**Our ref:** OR-0002993/01  
**Your ref:** EN010153  
**Date:** 29 April 2026

**ENVIRONMENT AGENCY DEADLINE 7 RESPONSE.**

**FRODSHAM SOLAR PROJECT, FRODSHAM MARSHES**

April 2025

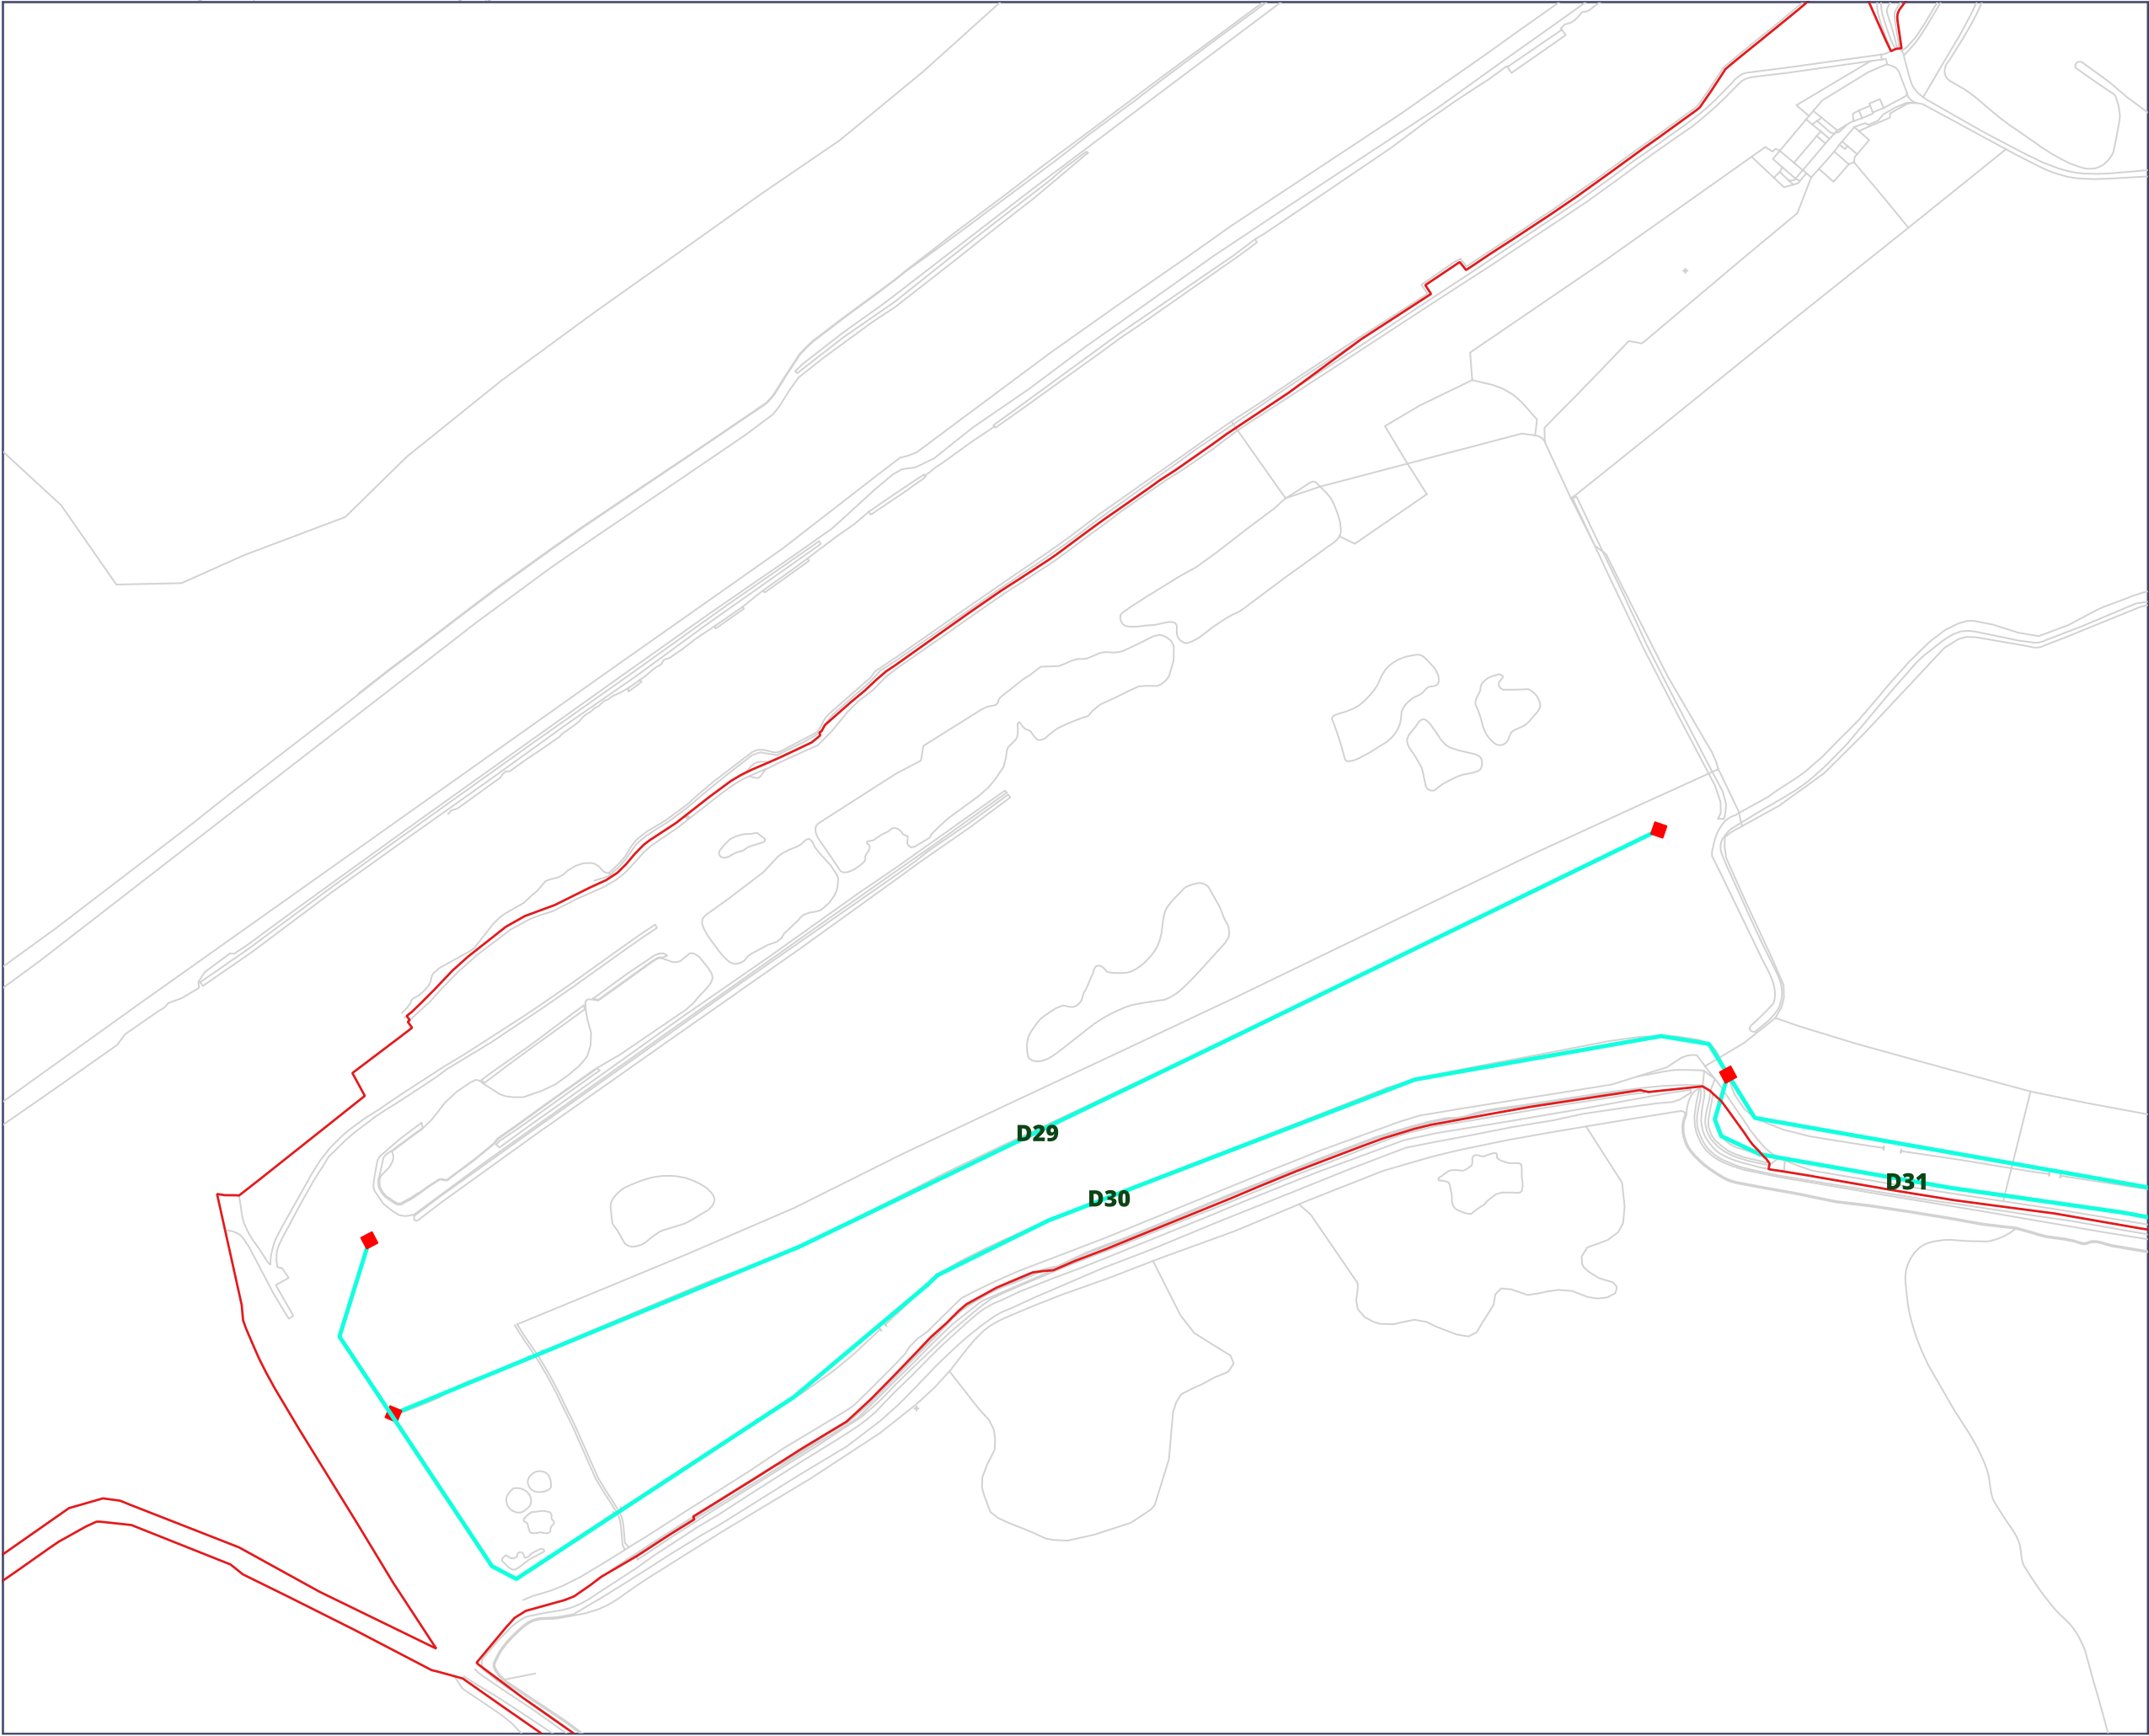
The Applicant has provided an adequate crossing design for bridge CP22 under the 8.52 CP22 Technical Note - P01 [[REP6-042](#)] that provides appropriate 300mm freeboard above the design flood event (1% AEP plus 67% CC - higher central allowance). We are content with the crossing designs for CP14 and CP17.
